# CITY OF ALBUQUERQUE

**Planning Department  
Transportation Development Services Section**

Re: Certification Submittal for Final Building Certificate of Occupancy for  
Dion's Resturant NM#5, [L-21/D069]  
11000 Central SE  
Engineer's Stamp Dated 06/16/09

The TCL / Letter of Certification submitted on June 16, 2009 is sufficient for acceptance by this office for final Certificate of Occupancy (C.O.). Notification has been made to the Building and Safety Section.

Public Infrastructure shown
on these plans for information
only and not part of approval.
Separate DRC/Permit approval
and Work Order required.

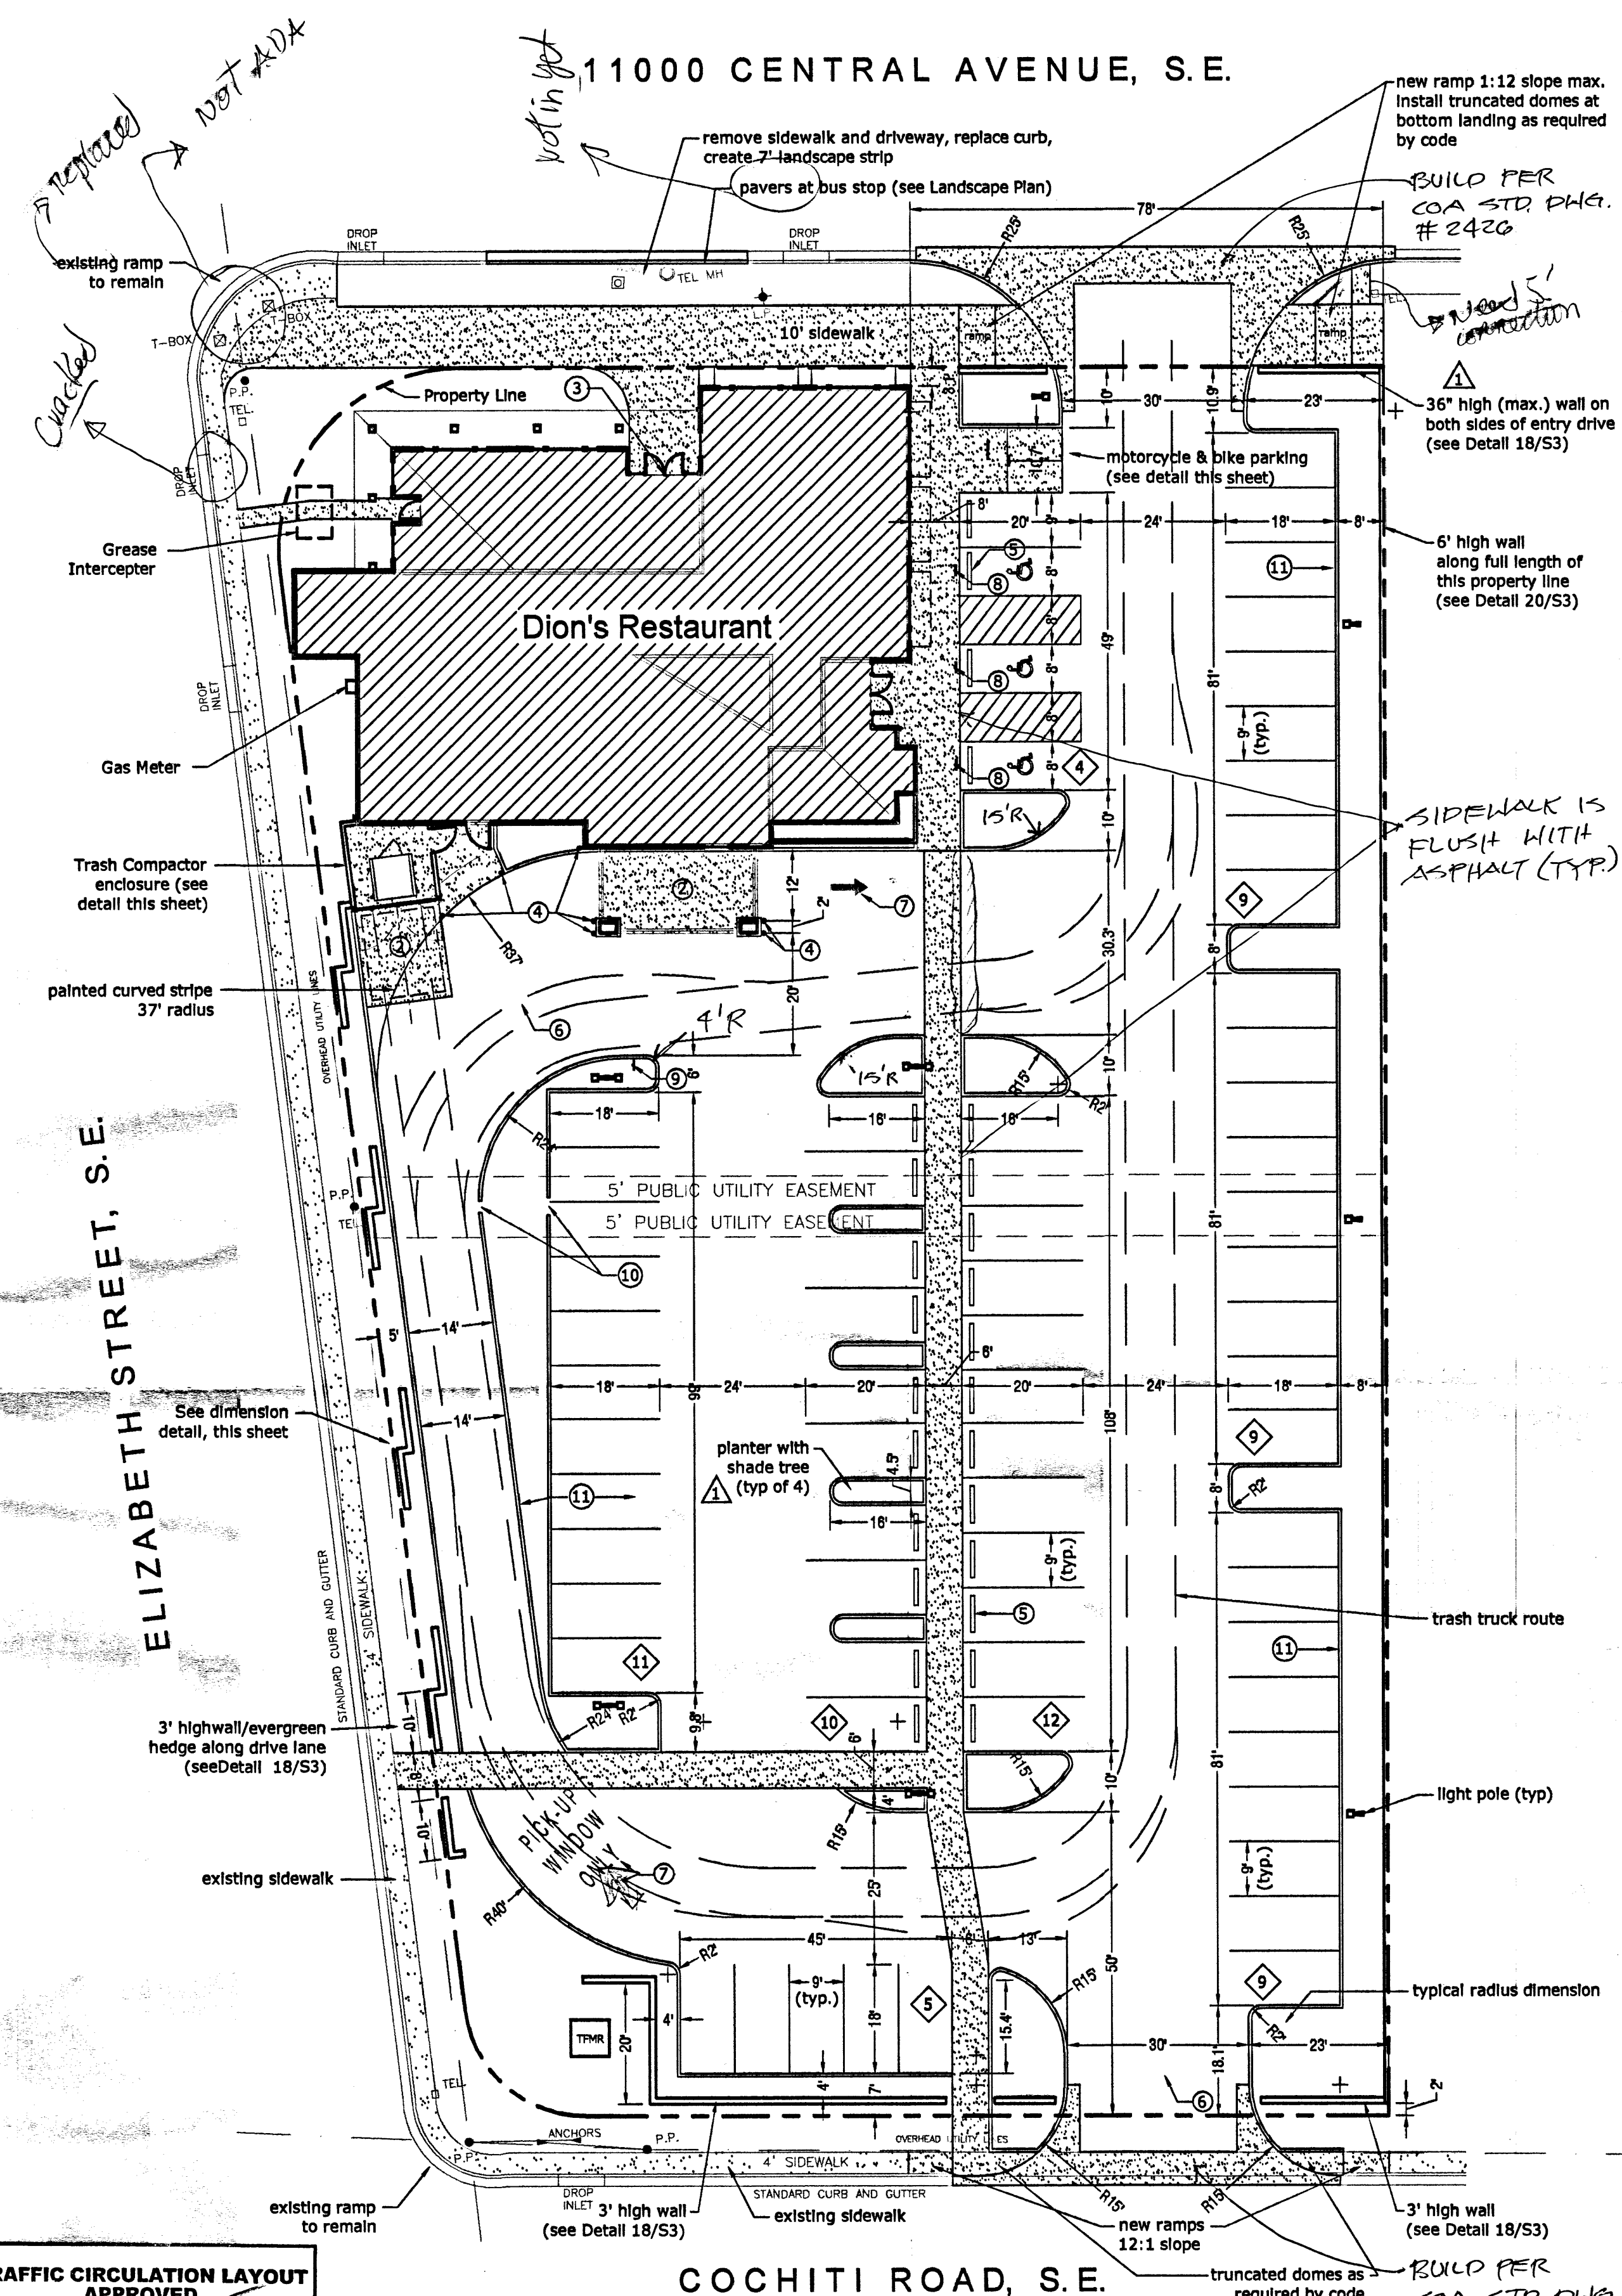
A Temporary C.O. has been issued allowing the outstanding Approved Site (need to provide the approved site plan dated 10/23/08), Central Ave. Infrastructure (entrance eastern ramp and sidewalk connection will need to be 5' in width; wheel ramp at the corner of Elizabeth St. is not ADA; and cracked sidewalk adjacent to ramp will need to be replaced), missing pavers for bus stop need to be in place, and drive thru pavement markings (will need a pavement directional arrow prior to pavement markings) issues to be completed within this time period. When these remaining issues have been fully completed, are in substantial compliance, and a final Certification for Transportation has been resubmitted to the City's Hydrology office for approval, a Permanent C.O. will be issued.

1. List radii for all curves shown.
2. For passenger vehicles, the minimum end island radius is 15 feet.
3. Build notes are needed for the proposed curb cuts. Please refer to all applicable city standards.
4. Please ensure all ramps are ADA compliant.
5. Is there a median break along Central Avenue at the site? If the site has left turn access, the drivepad has a 36-foot minimum width.
6. Is the sidewalk along the building flush with the pavement?

Call out all radii

15' min R

Need Build notes for proposed entrances  
- refer to CoA Std 2426

Entrance off Central - median  
access?
